ExQ1	Question to:	Question:
<b>1. General and cross-topic questions</b>		
Q1.1.1	The applicant	<p><b>Consultation on National Policy Statements</b></p> <p>The Government published on 24 April further consultation on each of the National Policy Statements (NPS) EN1, EN-3 and EN-5. The consultation period closed on 29 May 2025. Please advise if there are any areas of these documents that you consider the ExA should regard as important or relevant to the consideration of the proposed development.</p>
Q1.1.2	The applicant	<p><b>Assessment of environmental effects</b></p> <p>Noting the 40-year operational life of the proposed development, have its effects been assessed as temporary or permanent?</p>
Q1.1.3	The applicant	<p><b>Grid Connection</b></p> <p>The <a href="#">changes to the grid connection process</a> introduced by Great Britain's National Energy System Operator on 8 December 2025, mean that projects are prioritised where they are aligned to national energy targets and are ready-to-build, such as those with planning permission or land rights. As a result, energy generation projects have been informed of whether they are among the 283 GW of projects that will move forward now.</

Great North Road Solar and Biodiversity Park
Environmental Statement

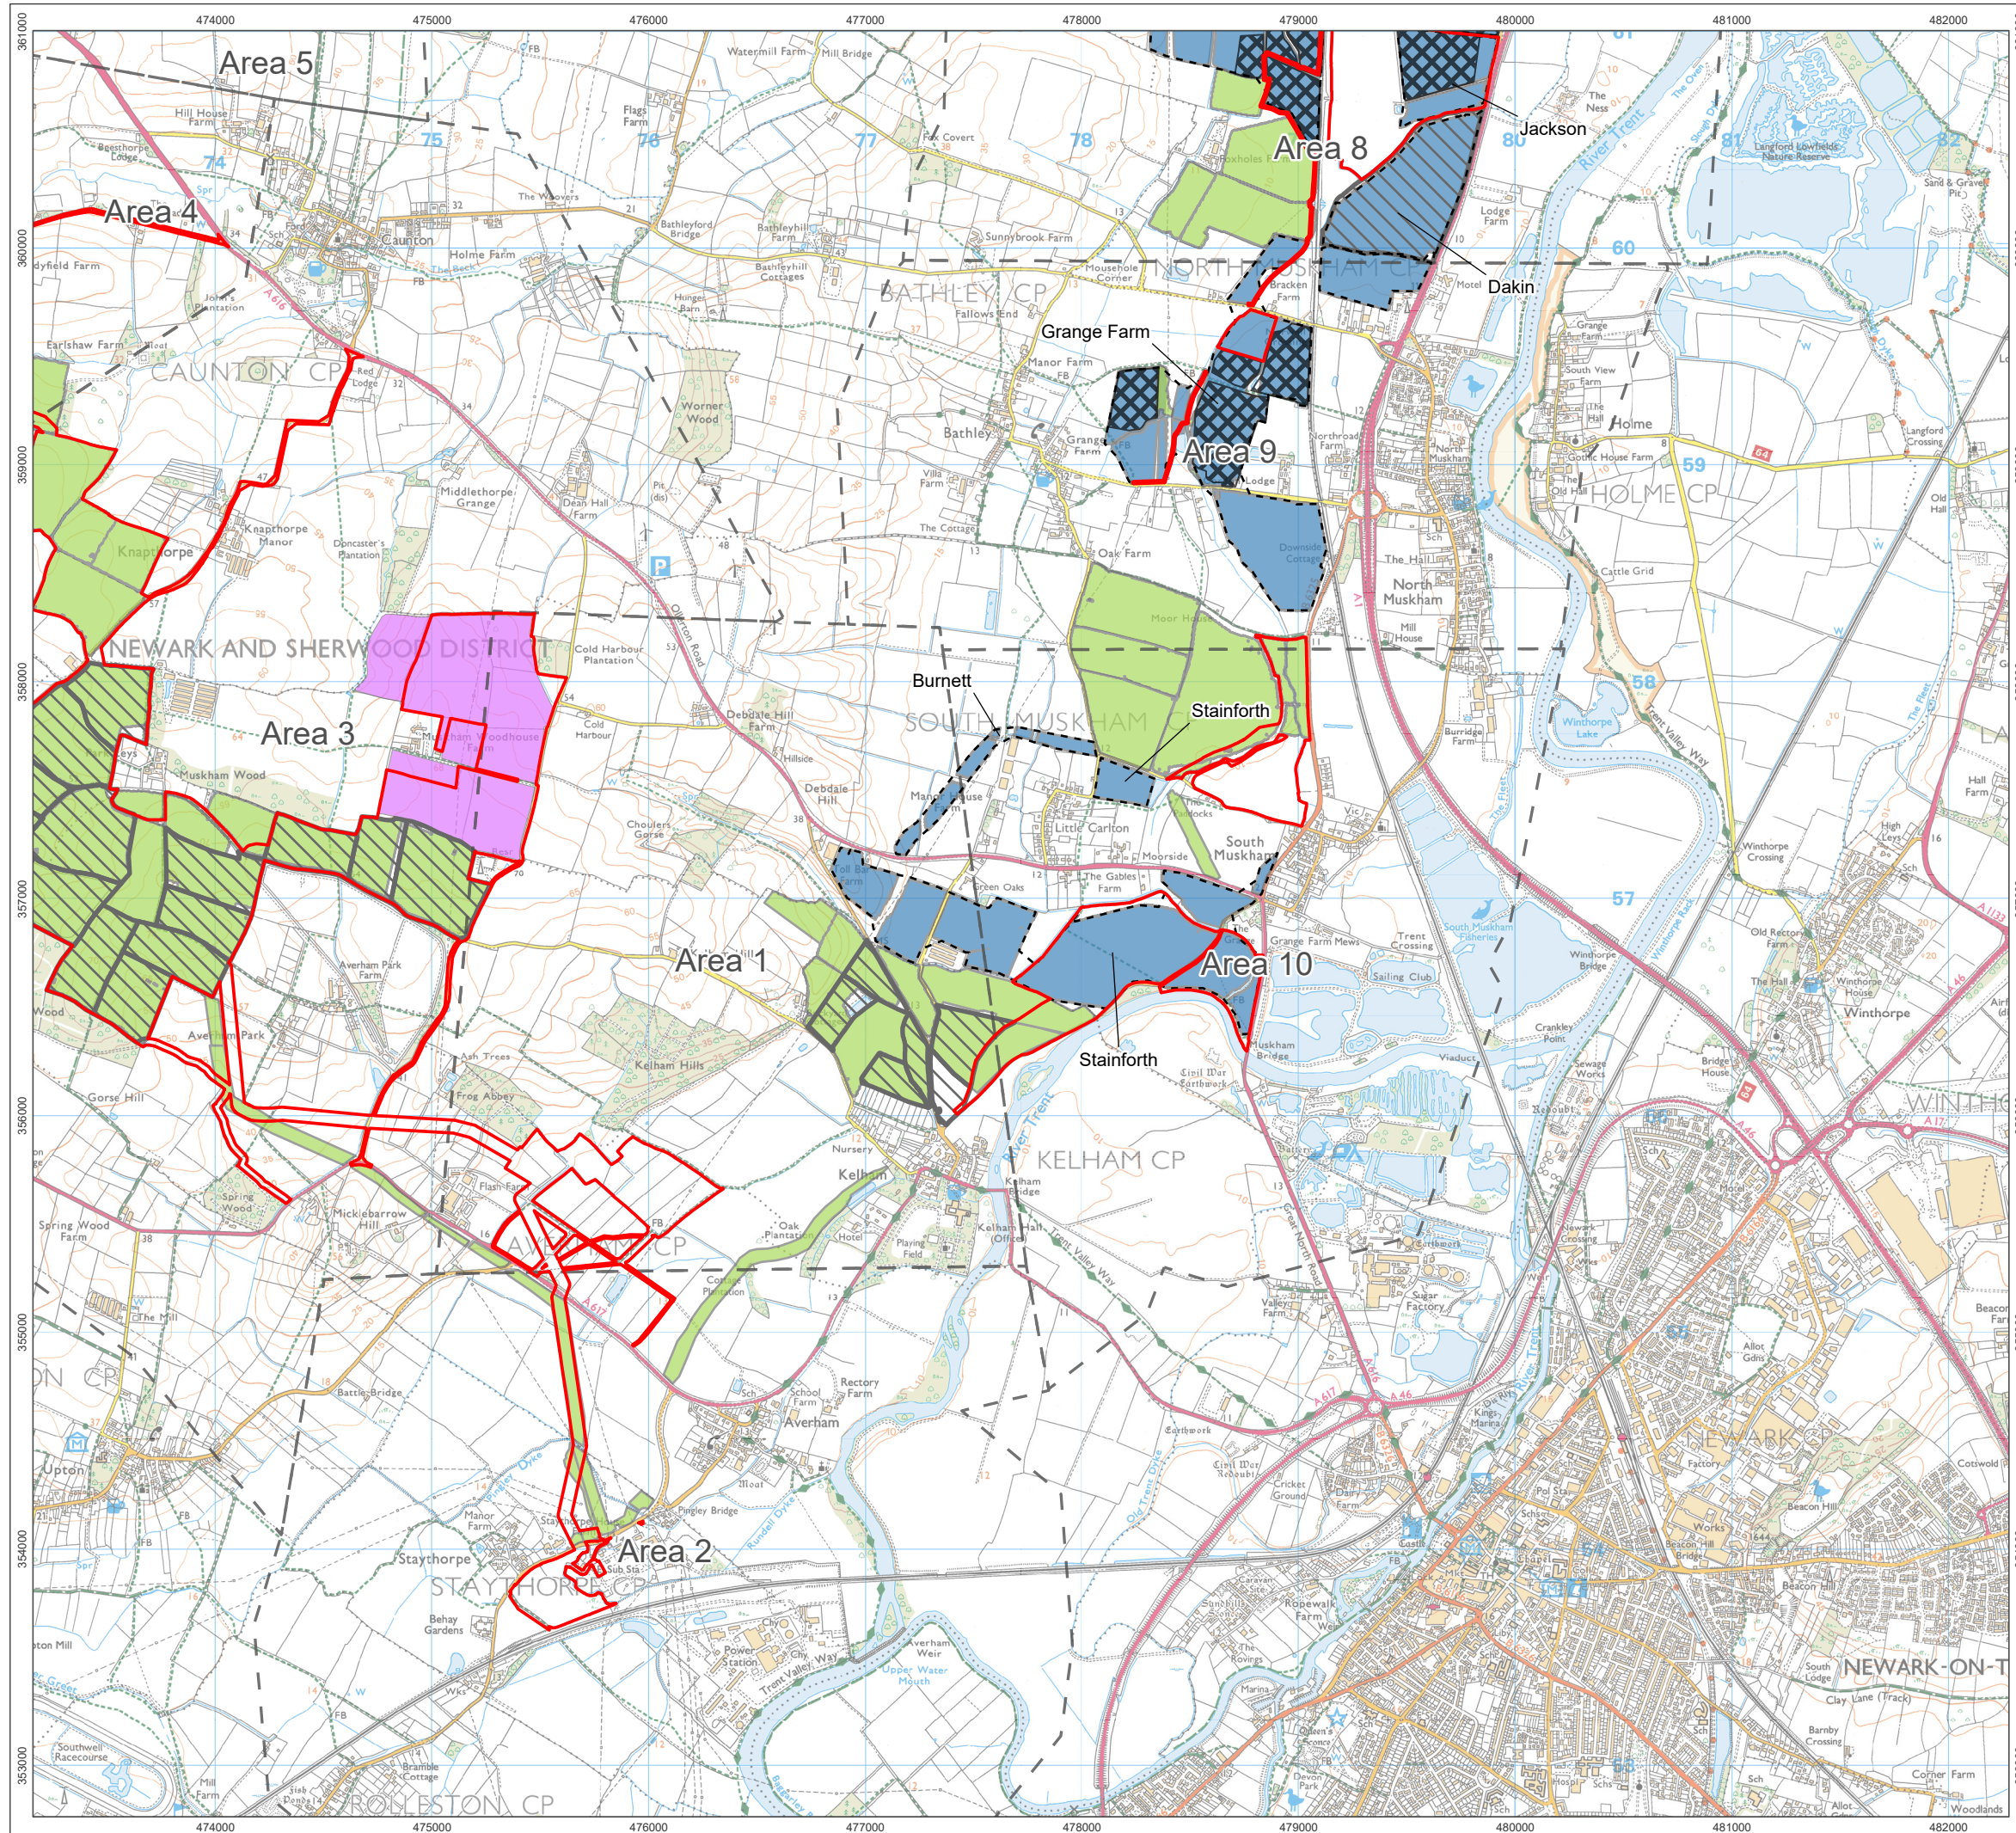
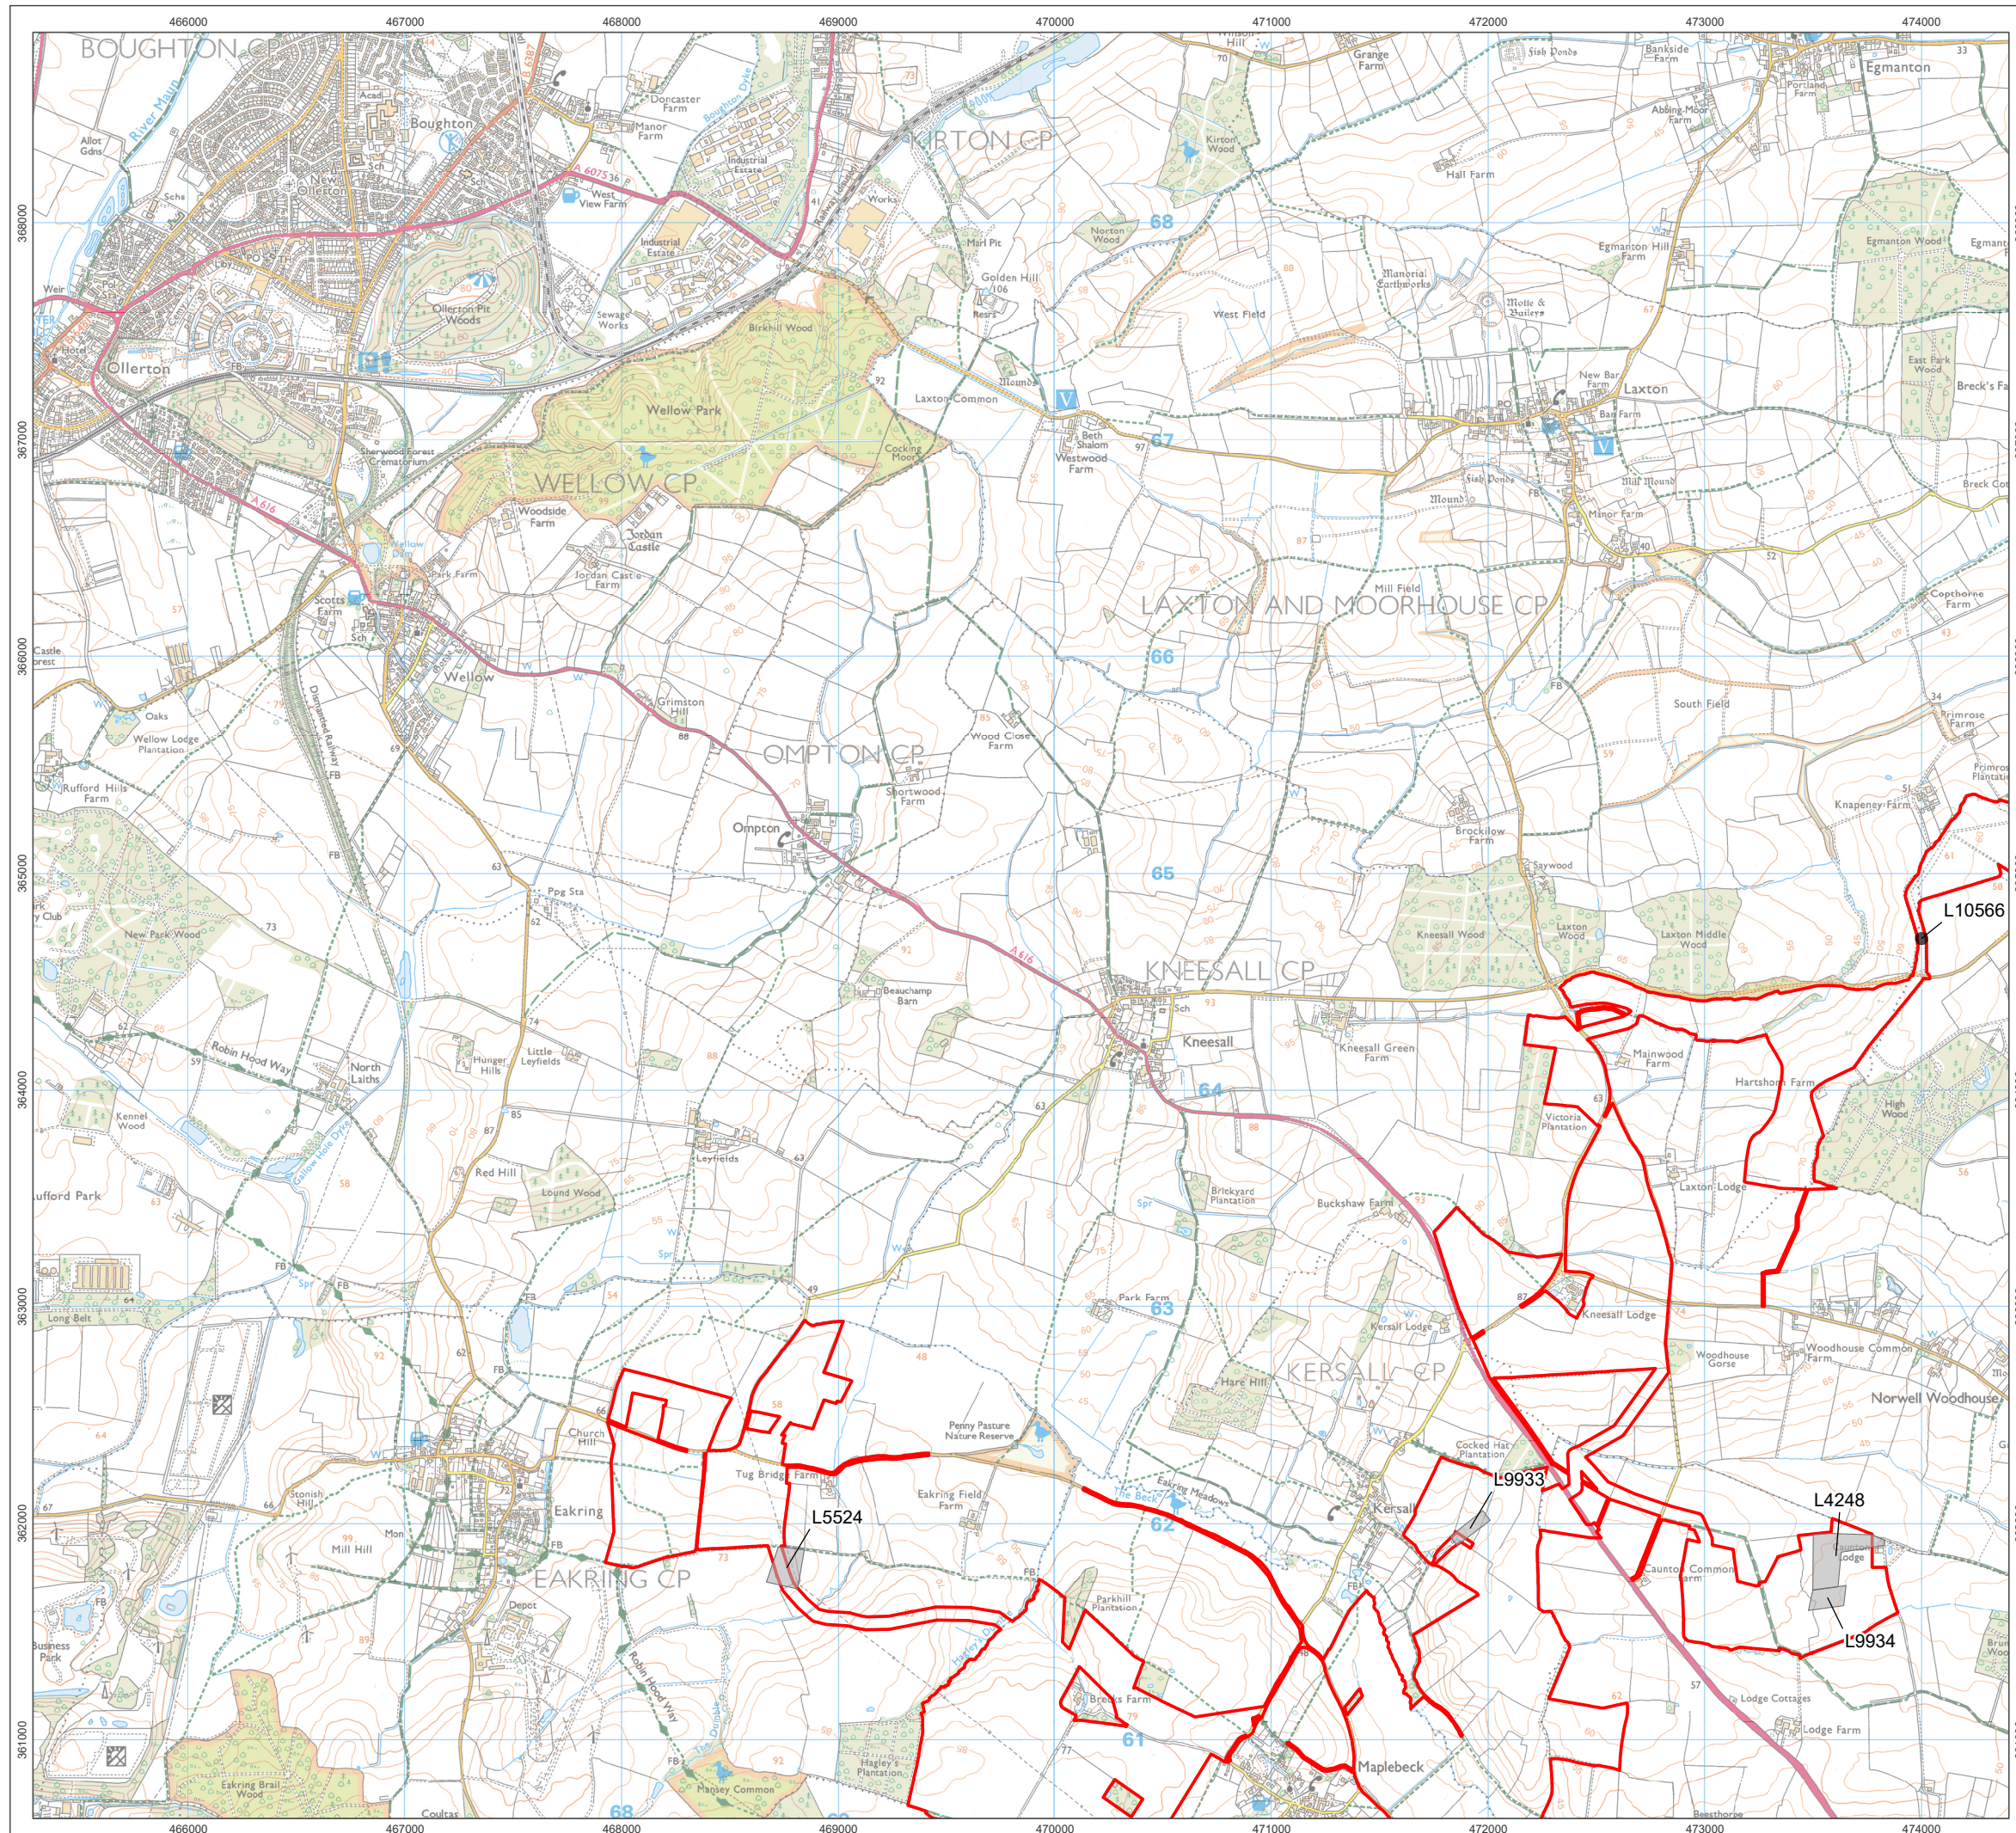
Q8.1.5	The applicant	<p><b>Phase 1 Geophysics Results</b></p> <p>The Technical Appendix A11.4: Phase 1 Geophysics Results <a href="#">APP-257</a> section 2.1 and section 5.2 set out that the survey area covers 542ha.</p> <p>However, the ES Chapter 11 <a href="#">[APP-054]</a> section 11.6.2.5 para 95 sets out that the phase 1 geophysical Survey covered approximately 1,837 ha and the Phase 2 Geophysical Survey covers 515 ha. Please clarify this discrepancy.</p>
Q8.1.6	The applicant	<p><b>Phase 1 Geophysics Results</b></p> <p>Section 9 of the Technical Appendix A11.4: Phase 1 Geophysics Results <a href="#">APP-257</a> sets out preliminary conclusions including reference to anomalies represent an extensive multi-period archaeological landscape, some of which are classified as ‘Unknown Features’ whose archaeological origins cannot be excluded. The outline Archaeological Mitigation Strategy <a href="#">[APP-269]</a> para 35 also states that the results of these surveys were used to inform the design of the development.</p> <p>Could the applicant please clarify specifically how the design of the development has responded to the survey findings.</p>

Q8.1.7	The applicant	<p><b>Phase 2 Geophysics Results</b></p> <p>Section 1.1 of Technical Appendix A11.5: Phase 2 Geophysics Results <a href="#">[APP-258]</a> sets out that this is an interim report and that the geophysical survey commissioned was over an area of approximately 635ha, though the report covers an area of around 515ha.</p> <p>The survey area for this stage of the project consists of 78 previously unsurveyed land parcels measuring (c. 635ha) located north of Ossington, east of Kersall, west of Maplebeck and north of Averham (Figure 1-4).</p> <p>The applicant is asked to please clarify how these areas were identified? Why was the full 635ha not covered and, of this area, which areas were excluded?</p>
Q8.1.8	The applicant	<p><b>Phase 2 Geophysics Results</b></p> <p>The conclusions of the Phase 2 Geophysics Results <a href="#">[APP-258]</a> at section 8.0 set out a number of findings, including that the survey identified three main areas of archaeological activity within the survey area. These areas comprise anomalies indicative of probable cut features, containing anthropogenically enhanced fill. The features include ditched enclosures, ring ditches, former field systems, and discrete pits. These anomalies appear to form Iron Age/Roman/British enclosures with associated field systems. Other more-isolated anomalies have also been interpreted as possible/probable archaeological origin.</p> <p>What are the consequences/implications of these findings?</p>
